Reference No:	2025/62/92167/W
Site Address:	94, St John's Road, Birkby, Huddersfield, HD1 5EY
Description:	Erection of single storey rear extension with room in roofspace to create new single dwelling/flat (within a Conservation Area)
Recommending Officer:	Nicole Helliwell

DECISION - REFUSED

Officer Report

Reference No. 2025/62/92167/E

Project Name 94 St Johns Road, Huddersfield, HD1 5EY	
Drawing Title: Proposed Grouped Plans	
Drawing Number: TR-A25-0702-A5	Scale: 1 : 50@A1
Date: 15/07/25	Revision: Approver
Drawn By: AM	Checked by: JA
Reason For Issue: Planning

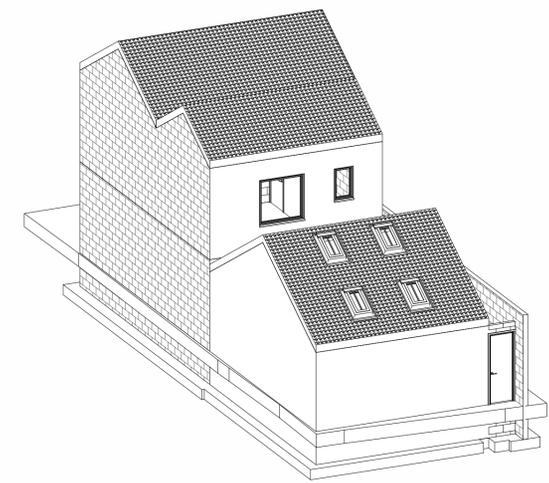
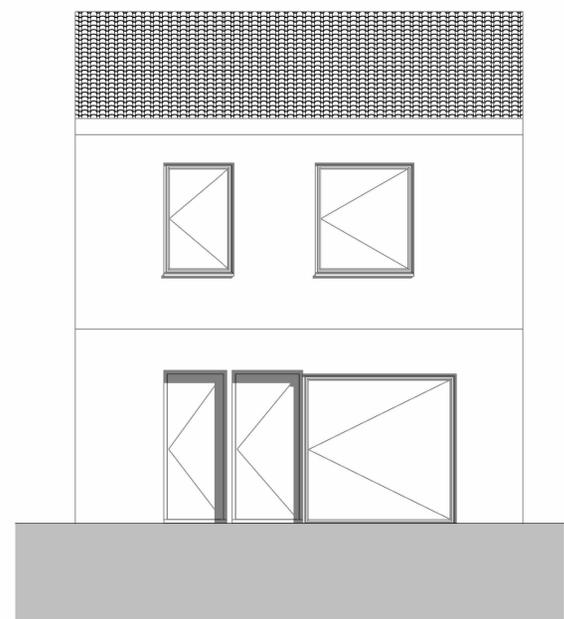
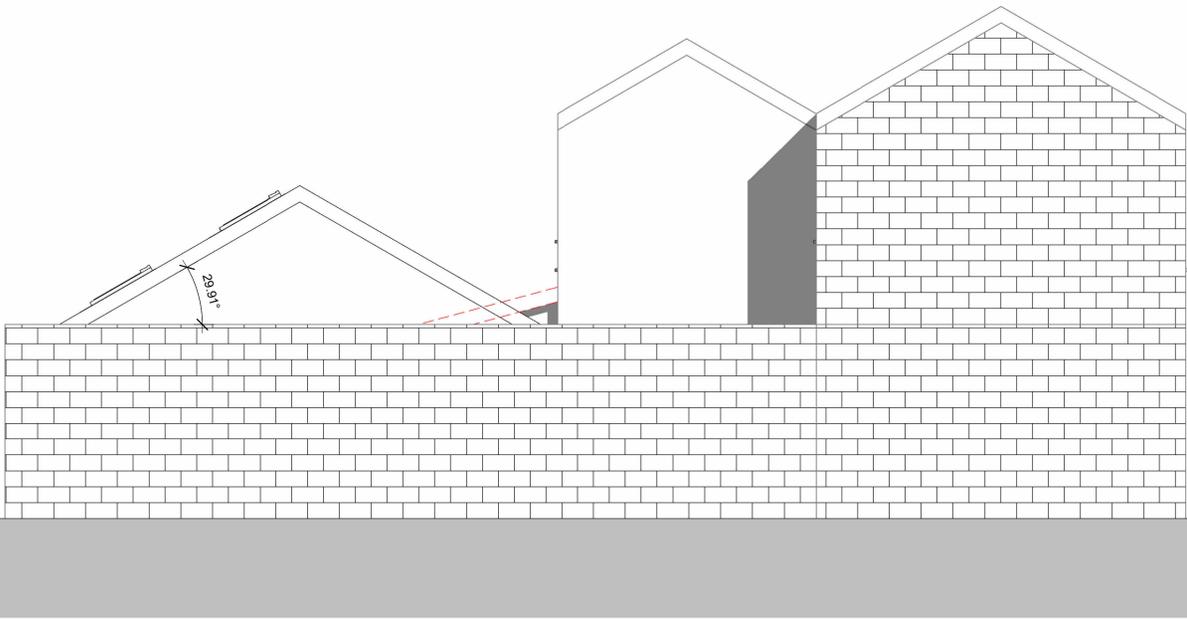
Principle 19 of the Housebuilders Design Guide SPD outlines how provision for waste storage and recycling should be incorporated into the design of new developments. Whilst the Proposed Grouped Plans document (drawing no. TR-A25-0702-A5) shows the location of a bin store, it is unclear whether this is just for the proposed flat or for the existing flat and shop as well. Its positioning appears to block access and the size of the storage may not be adequate. These constraints could lead to the bins being left on the access to the rear to the detriment of visual amenity and users of the access.

1. The submitted plans confirm a poor standard of amenity to the existing first floor flat at 94 St Johns Road. Bedroom 2 would have a restricted outlook and would receive limited light due to the location, height and scale of the proposed single storey rear extension. Therefore, the proposal would provide an unacceptable standard of living for occupants of the flat failing to accord with Policy LP24(b) of the Kirklees Local Plan, Principles 6 and 16 of the Council's Housebuilders Design Guide SPD, and Paragraph 135(f) of the National Planning Policy Framework.

2. The submitted plans show a cramped layout resulting in a poor standard of amenity to the occupants of the proposed ground floor flat. Due to the contrived internal layout which does not have windows, the bedroom would have no outlook and would receive no natural light. Therefore, the proposal would provide an unacceptable standard of living for future occupants and would fail to accord with Policy LP24(b) of the Kirklees Local Plan, Principles 6 and 16 of the Council's Housebuilders Design Guide SPD, and Paragraph 135(f) of the National Planning Policy Framework.

Drawing Title:
Location & Proposed Site Plan

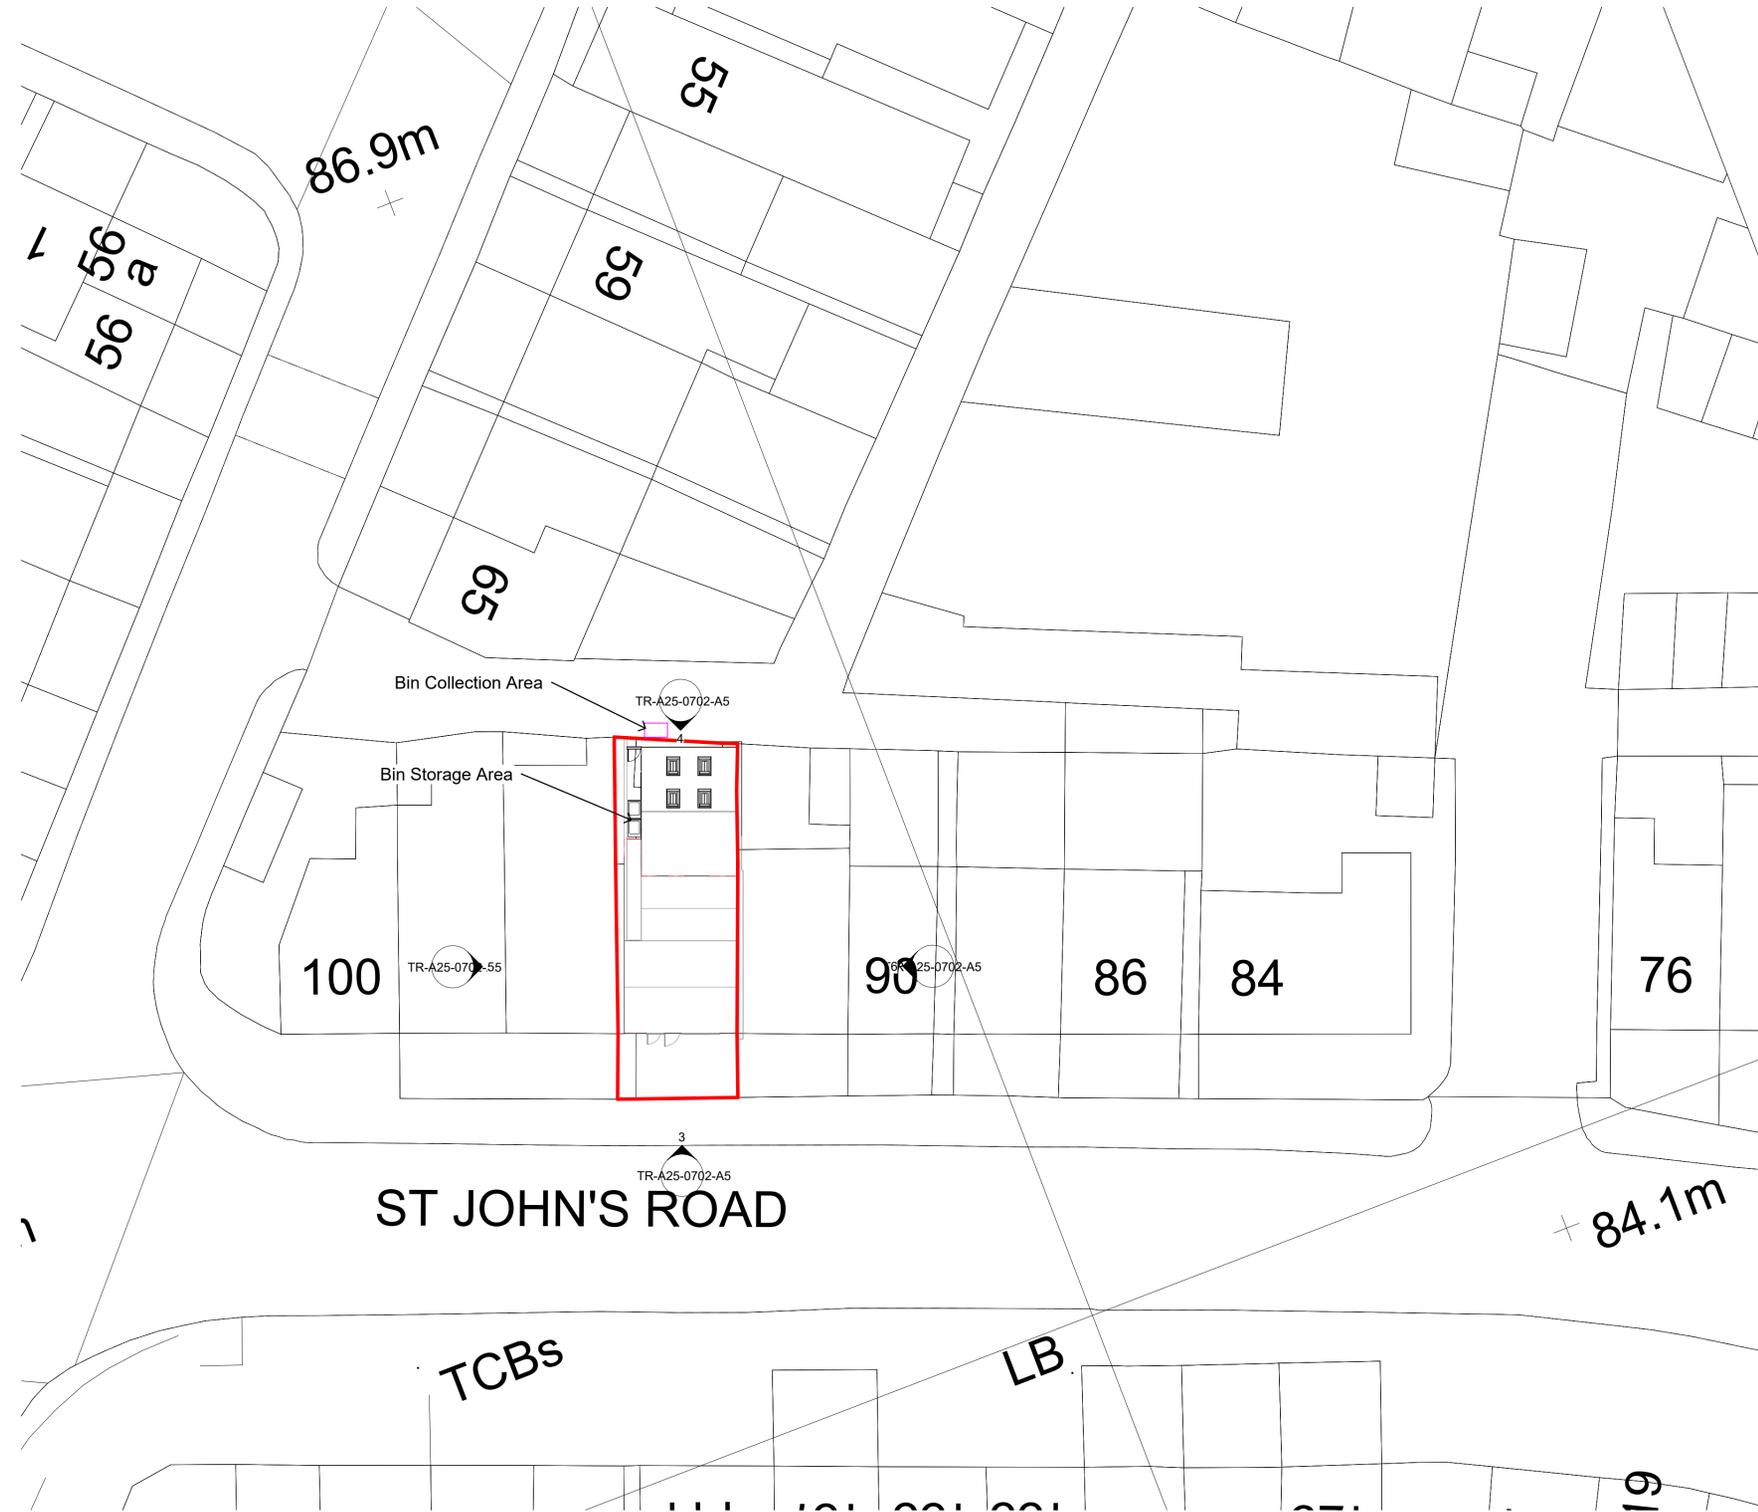
92 St Johns Road is the adjoining property located east of the application site. The submitted site plan confirms that the proposed single storey rear extension would extend beyond the 45 degree rule in relation to the neighbour's ground floor fenestration. However, the extension would occupy a similar position to the existing single storey rear projection and the previously demolished garage and would be screened to some extent by the existing boundary treatment. For these reasons, it is considered that the proposed development would not cause any undue harm to the neighbouring occupants with regards to overbearing, overshadowing or overlooking.
